In reply please quote: 12/02624

29 August 2011

HORSLEY DRIVE BUSINESS PARK – SSD 5169 – PUBLIC EXHIBITION OF STATE SIGNIFICANT DEVELOPMENT

**Figure 3.2: Preliminary Concept Masterplan Layout** (Source: Hansen Yuncken)

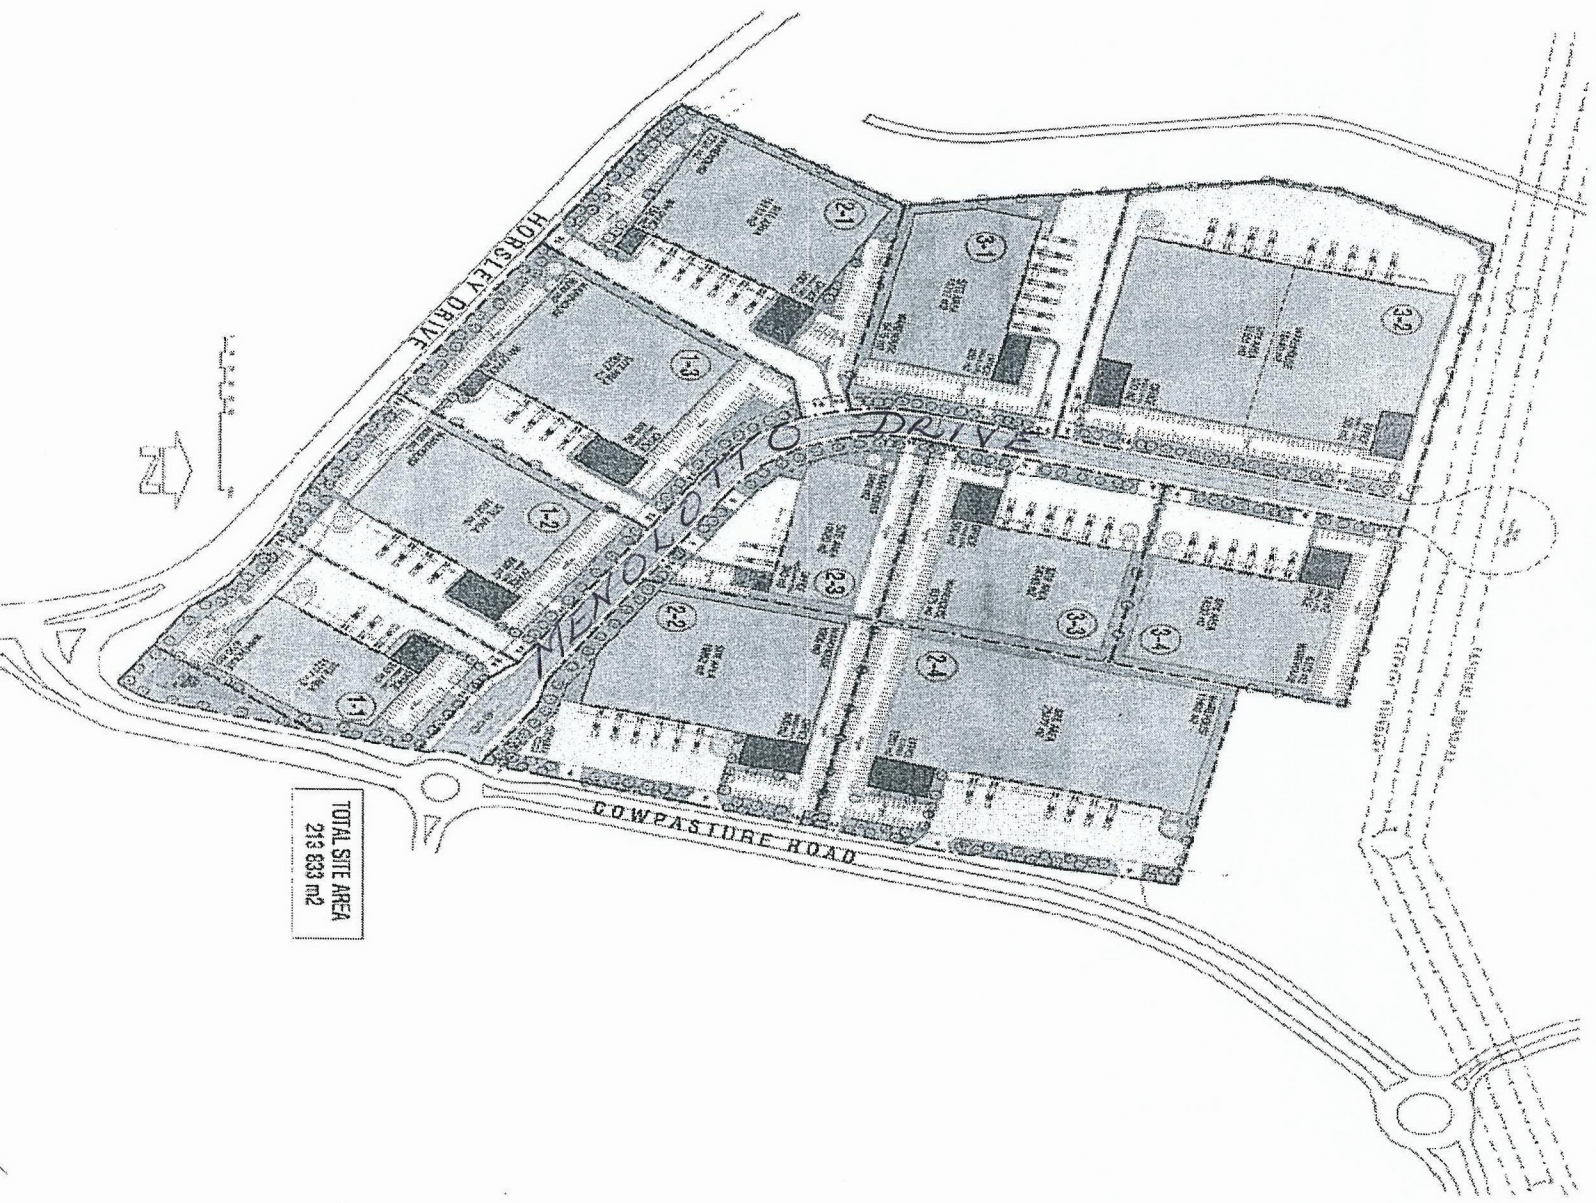
Plans submitted for the proposal indicate a proposed setback for the development ranging from approximately 10 – 14 metres along The Horsley Drive and Cowpasture Road. In addition, future industrial development along

The Horsley Drive would be located on elevated 'pads' positioned approximately 3m above the roadway.

These arrangements are considered inadequate given the gateway and landscaped character of the area.

To soften the visual impact of future industrial development, it is recommended a full 20m landscaped setback be applied along entire frontage of the site to The Horsley Drive being the principle western entrance into Wetherill Park. This frontage also has a strong visual relationship with the Parkland area to the south. To achieve this setback there is scope to reduce setbacks along the internal access roads.

To enhance the landscape character of the site and achieve better transition to the surrounding Parklands, it is also recommended that a 20m landscape buffer be provided to the Business Park along the western and northern boundaries of the site. It is noted there is scope to include part of this buffer within the Parklands itself.

The EIS states that there will be no direct impacts on the tree. However concern is raised in regard to the proposed construction of a retaining wall associated with a stormwater detention basin (to service the Business Park) located approximately 3 metres from the tree.

The proponent has not submitted a report from a relevant professional (arborist) confirming that there will be no detrimental impacts on the tree. This should be undertaken and if necessary the detention basin redesigned to ensure survival of the Bunya Pine. The tree also needs to be adequately protected from accidental damage during construction work and a condition is included in Attachment A to address this issue.

5. *That a minimum landscape setback of 20 metres be provided to The Horsley Drive frontage of the site. A 20 metre buffer also to be provided along the western and northern boundaries of the site some of which may be incorporated within the Parklands.*

8. *A report is required from a qualified arborist confirming that there will be no detrimental impacts from the proposed stormwater detention basin adjoining the heritage listed Bunya Pine located on the corner of The Horsley Drive and Cowpasture Road. If necessary based on this report, the detention basin is to be redesigned to ensure the Bunya Pines survival.*
